21 December 2020

**RIDBC Centre of Excellence (SSD-10451)
Response to Submissions**

ATTACHMENT 1

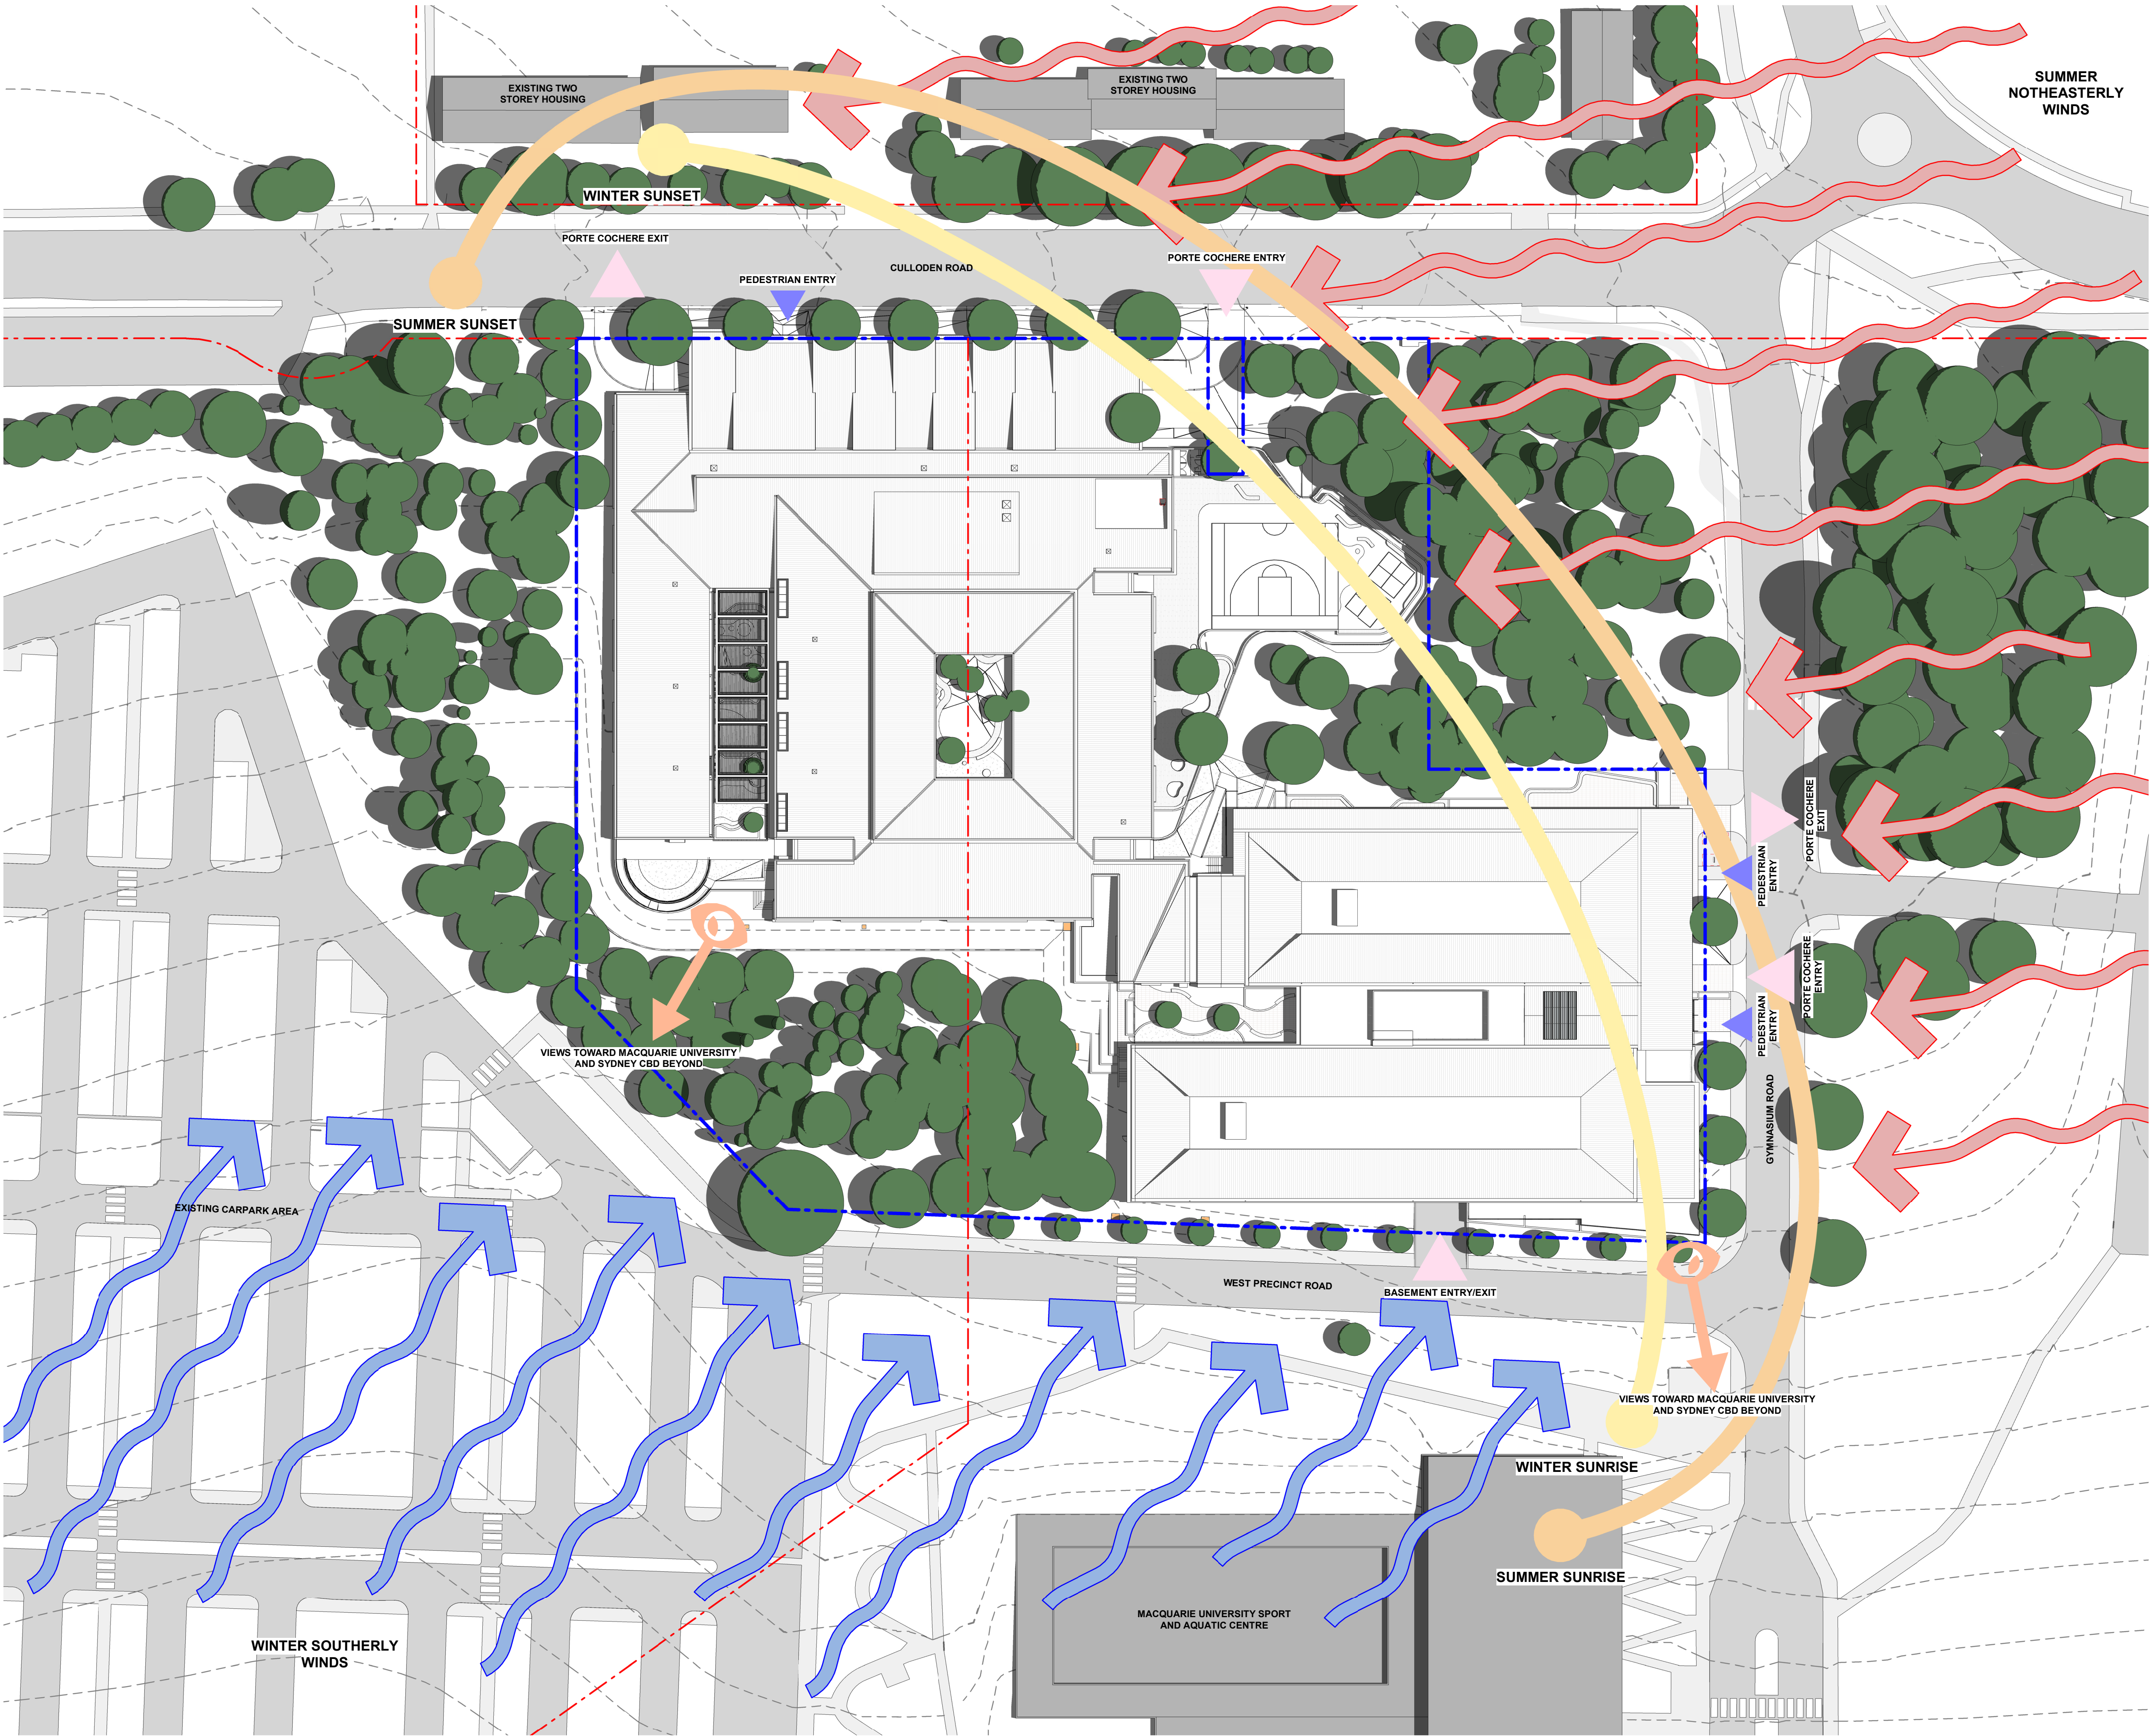
- The Department notes that the architectural plan set shows awnings overhanging the boundaries. You must provide additional information, clarifying whether the

development includes any works within the public domain (whether there are any awning overhangs).

SITE DEMOLITION PLAN

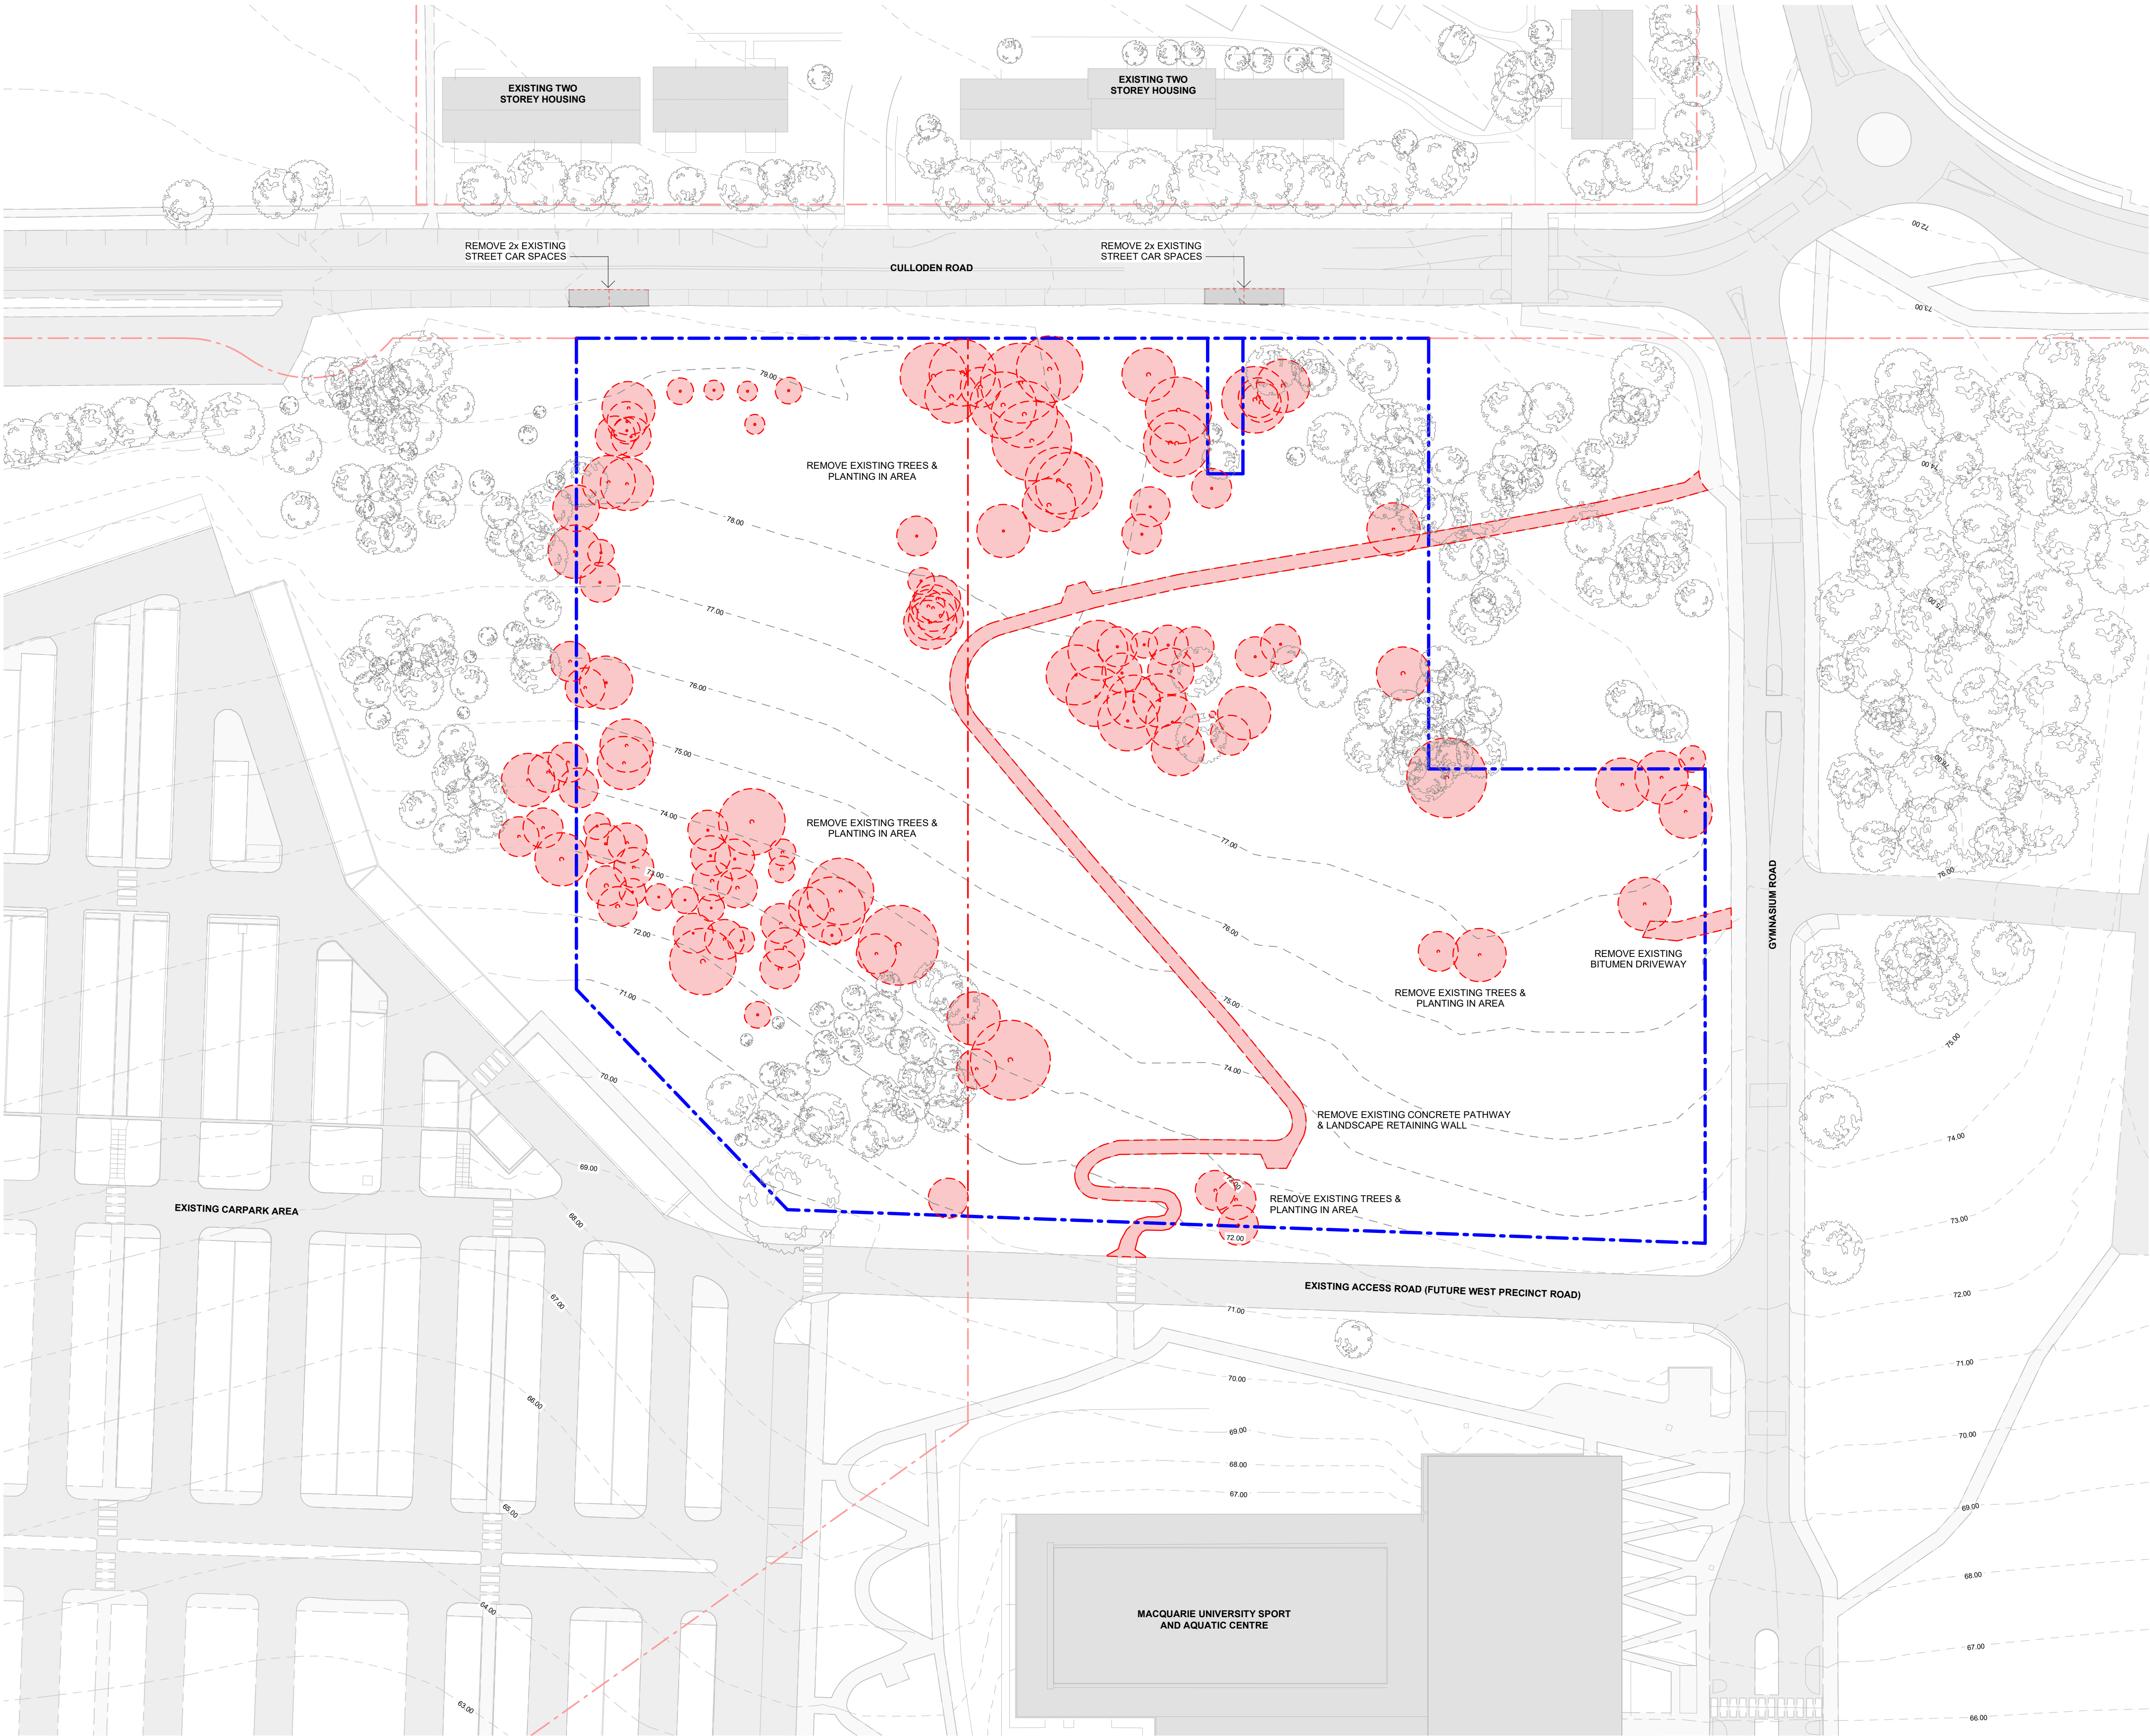
- The Department notes that Council has raised significant concerns regarding the environmental and visual impacts of the proposed tree removal, with particular concern regarding lack of a tree canopy along the Culloden Road frontage. The Department agrees with these concerns and requires you to investigate opportunities for further tree retention within the site.
- The proposed landscape strategy includes trees planted over underground structures. For example, the courtyard in the consulting building includes a feature tree (*Acer palmatum* 'Senkaki' 'Coral Bark Maple', mature size 6m x 5m) above the on-site

1 ELEVATION
OVERALL NORTH
SCALE 1 : 500

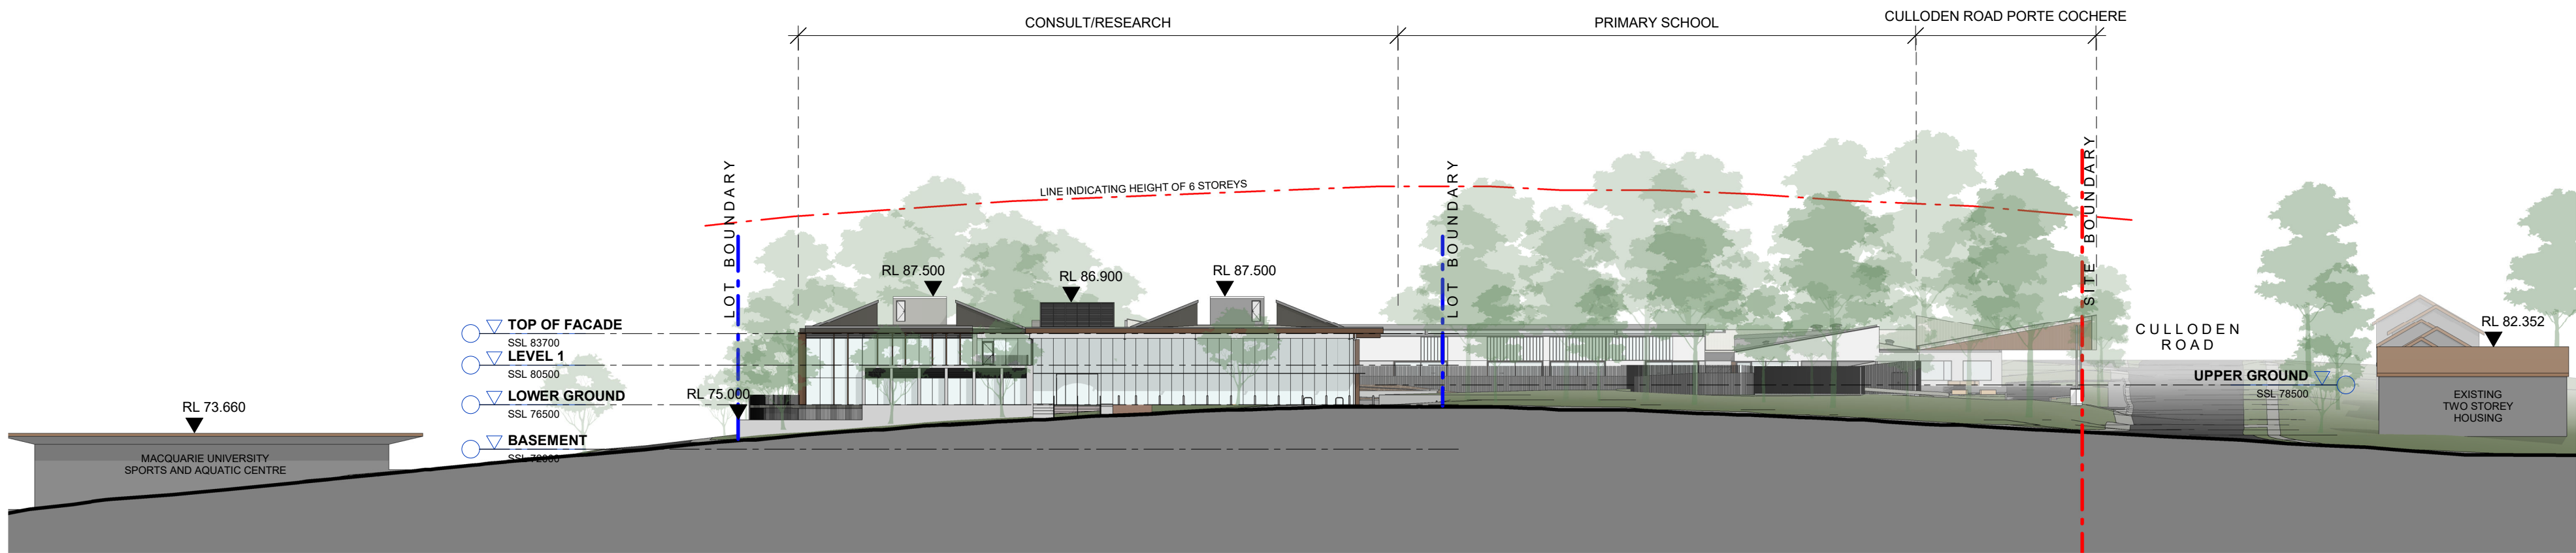
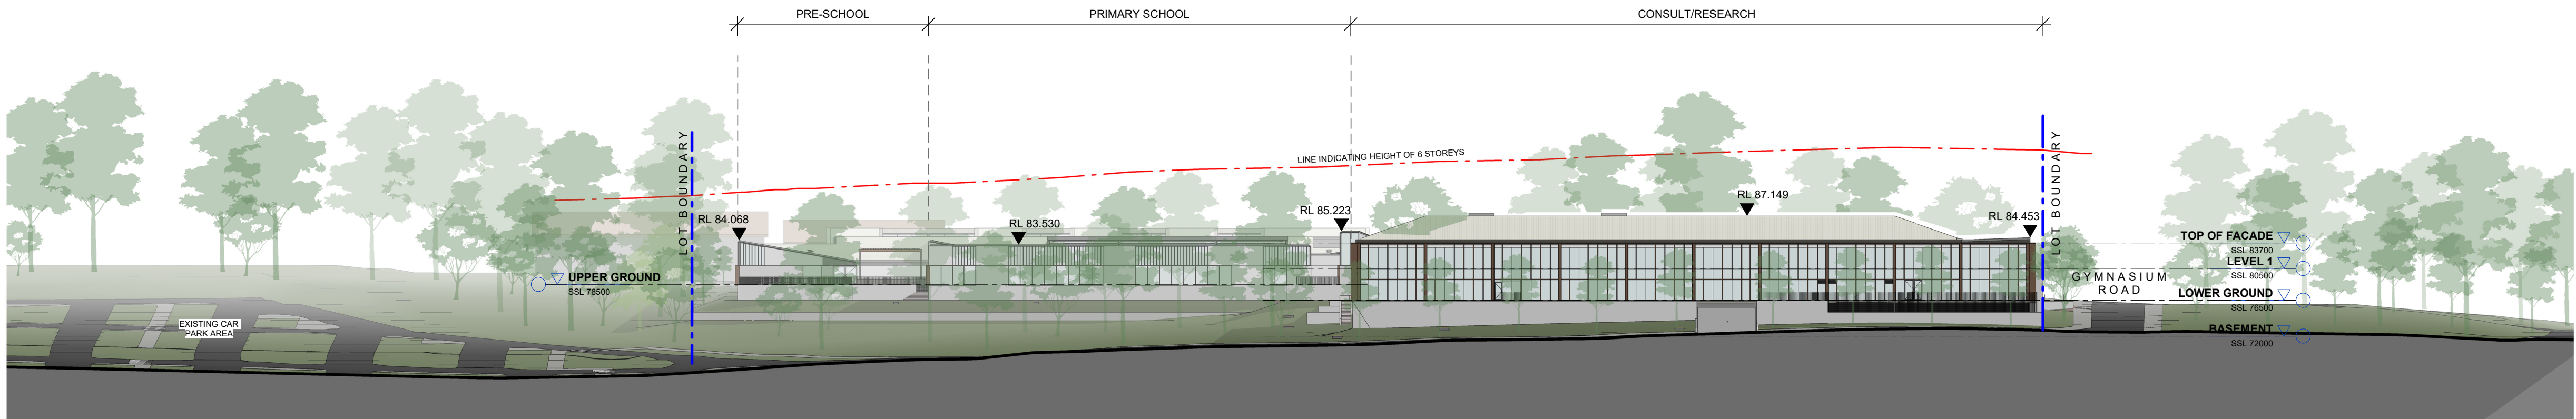
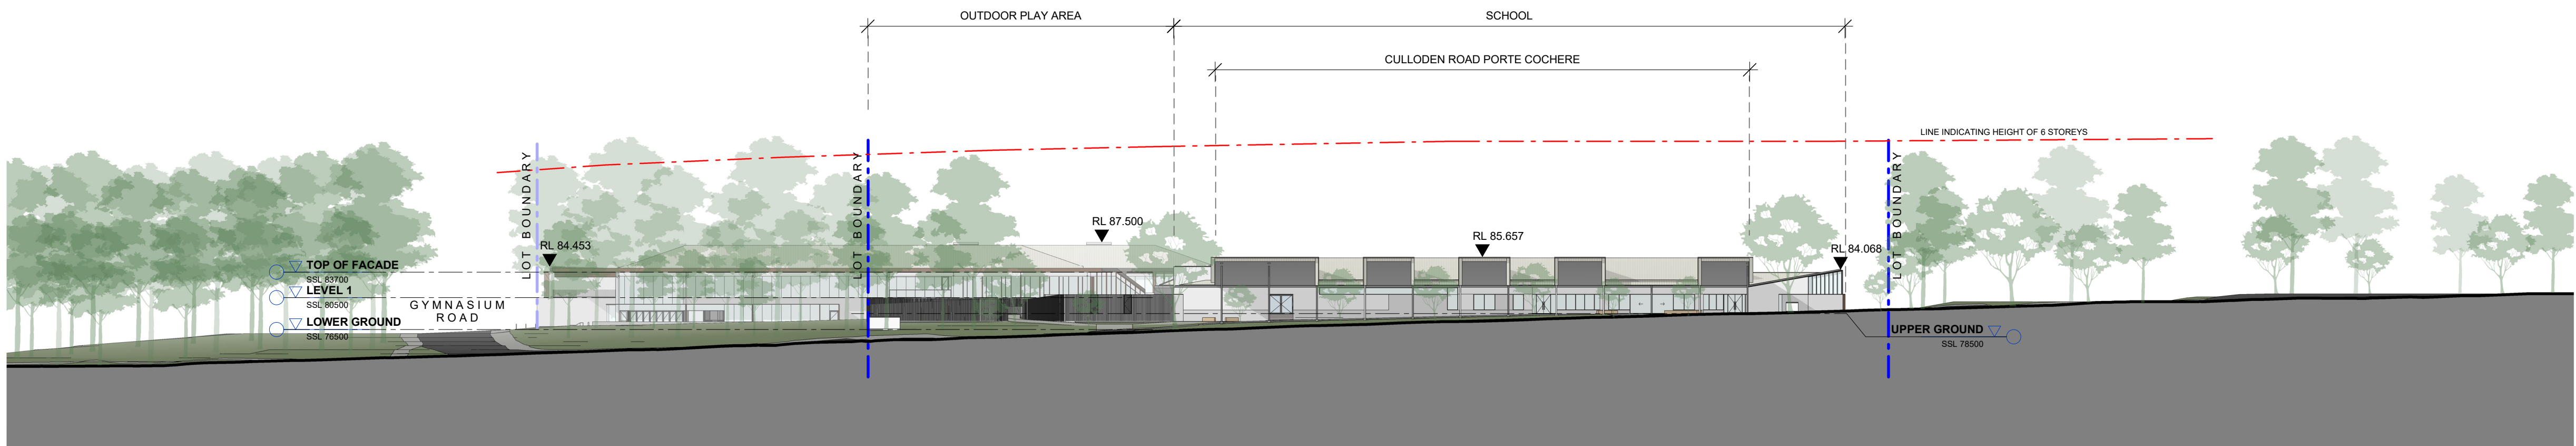
- The Department requires you to submit amended architectural plans including:
 - appropriate height information on all elevations and sections to ensure an appropriate assessment of the proposed maximum building height. The building height (in meters) should be provided considering the greatest vertical distance between existing ground level and the highest point of the buildings. The relative levels (RLs) of the topmost parts of the building should also be included.

- a line indicating existing ground level on all elevations and sections.
 - information on the height of the basement entrance level on elevations and sections to demonstrate the clearance height and that it can accommodate a medium rigid vehicle (MRV). The Department notes the Transport Impact Assessment outlines a “clearance height of up to 4 metres (m)” is provided, however this cannot be verified by the information available in the submitted plans.
